ENG-SF19001-R4-CD-Redlines.pdf Markup Summary

**C2.10**

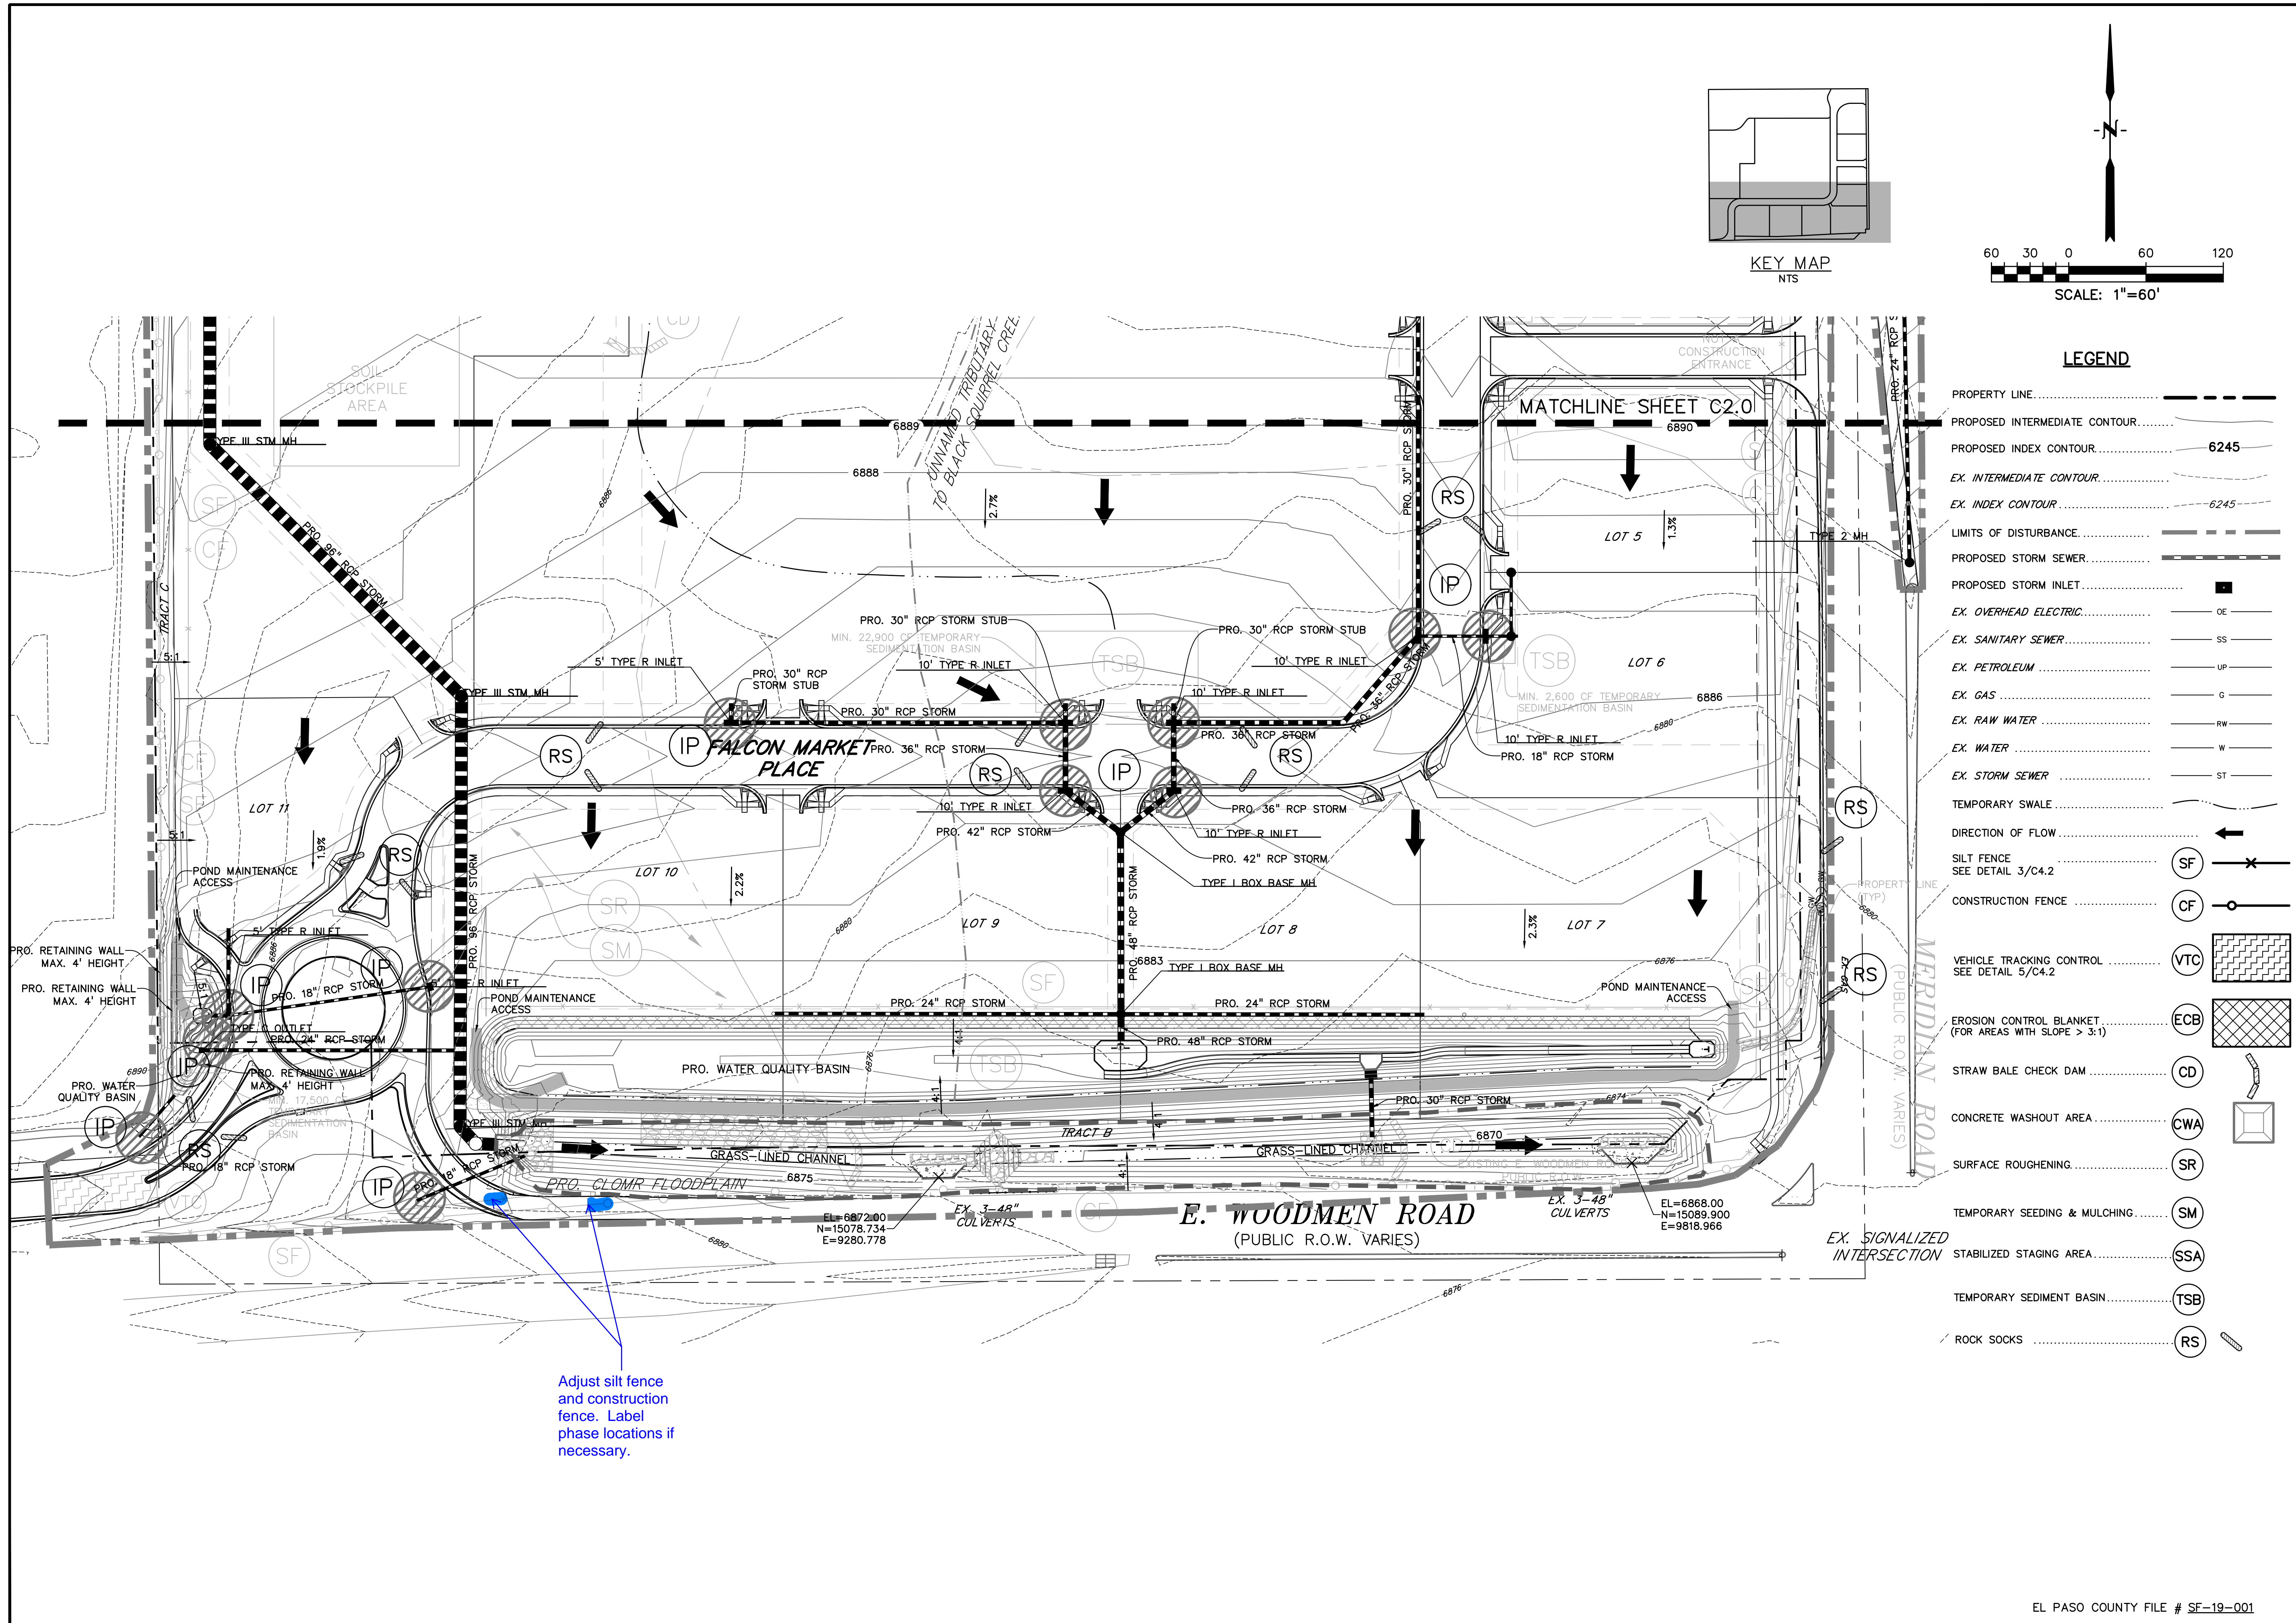
9 (3)	<div data-bbox="103 1509 277 1617"></div> <div data-bbox="295 1503 625 1724"><p>Subject: Callout Page Index: 9 Date: 10/10/2019 11:56:37 AM Author: dsdrice Color:  Layer: Space: Page Label: [1] Layout1</p></div> <div data-bbox="971 1520 1463 1577"><p>Adjust silt fence and construction fence. Label phase locations if necessary.</p></div>

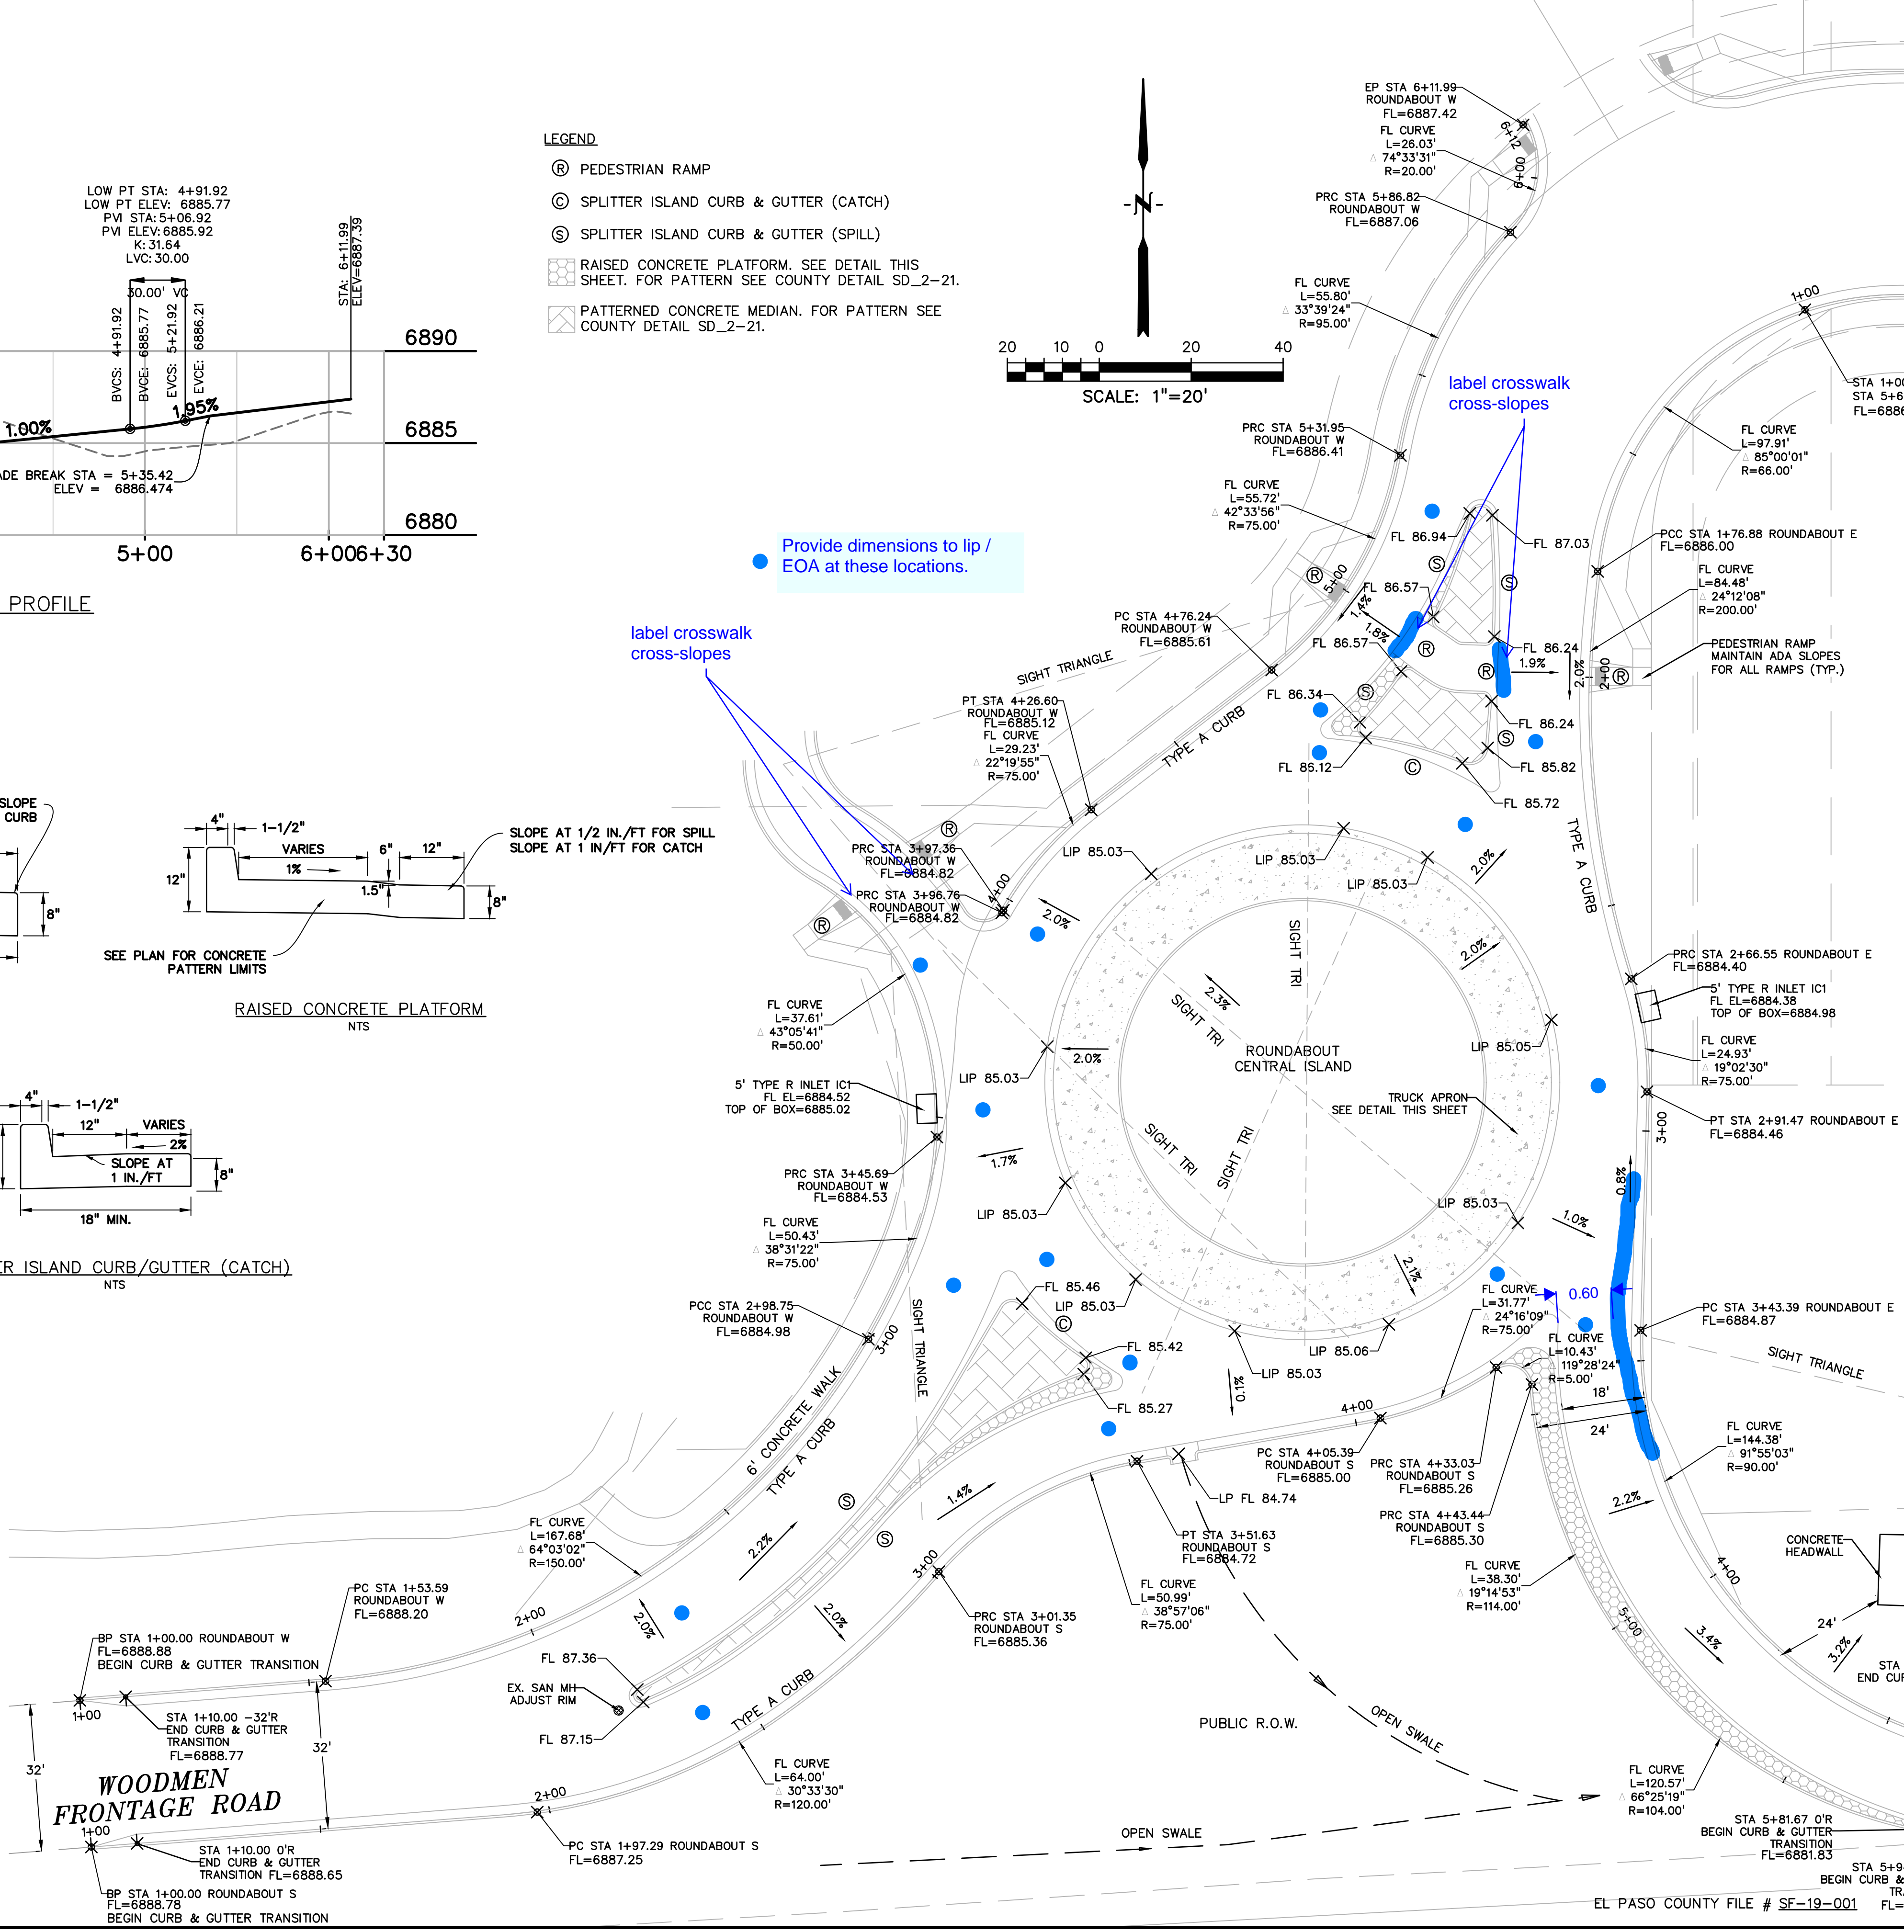
Provide dimensions to lip /
EOA at these locations.

Provide dimensions to lip / EOA at these locations.

label crosswalk cross-slopes

label crosswalk cross-slopes
